**RE: Perez Collision Center Addition
2415 2nd Street NW
Grading and Drainage Plan
Engineer's Stamp Date: 04/25/18
Hydrology File: H14D039**

Based upon the information provided in your resubmittal received 05/04/18, the Grading and Drainage Plan **is not** approved for Building Permit and SO-19 Permit. The following comments need to be addressed for approval of the above referenced project:

GRADING AND DRAINAGE PLAN

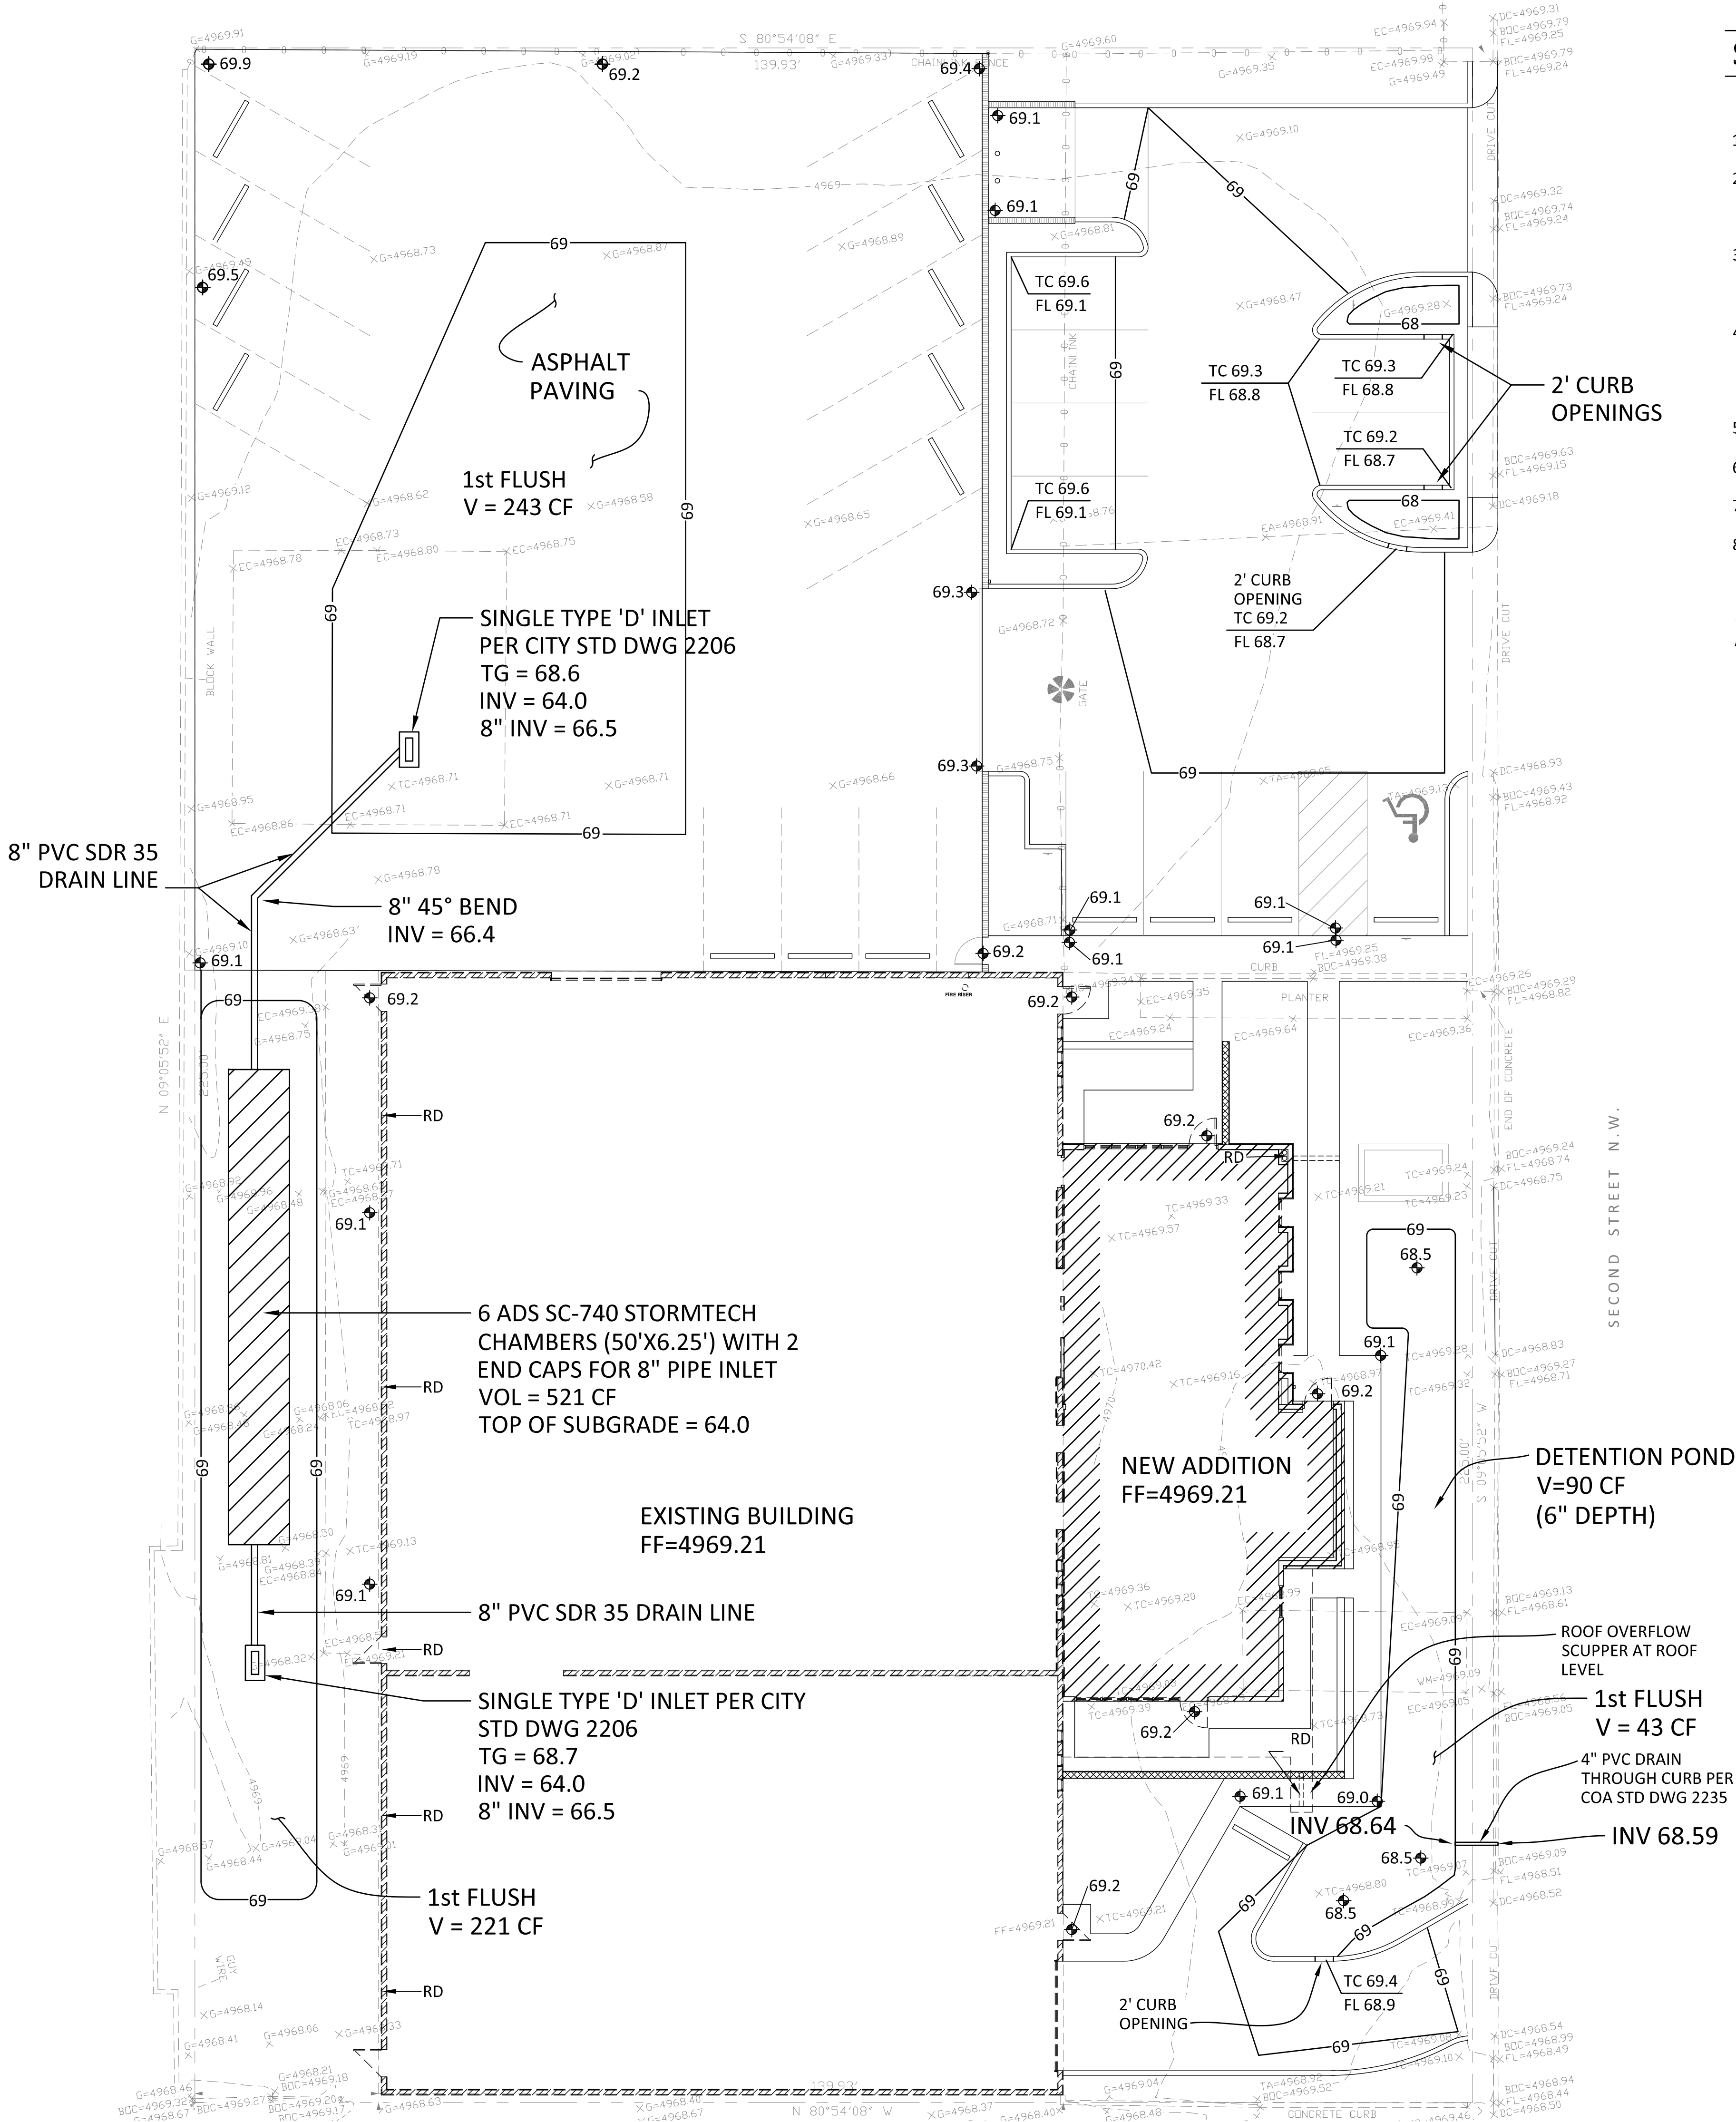
1. Please show each first flush pond volume.
2. Please provide the weir calculations for the curb cuts.
3. Please provide the inlet capacity calculations for the Type "D" inlets.
4. Please provide the invert elevations on both ends of the 4" PVC.
5. Please provide the flow calculations of the 4" PVC.
6. Please provide the drainage calculations for detention. If this is only a first flush pond then label it as first flush pond instead of detention.
7. Please provide the drainage calculations for the retention pond (ADS Chamber) 100 year – 10 day.

Please provide a Drainage Covenant per Chapter 17 of the DPM for Detention ponds and ADS underground chambers (retention pond) prior to Certificate of Occupancy. Please submit this on the 4th floor of Plaza de Sol. A \$25 fee will be required.
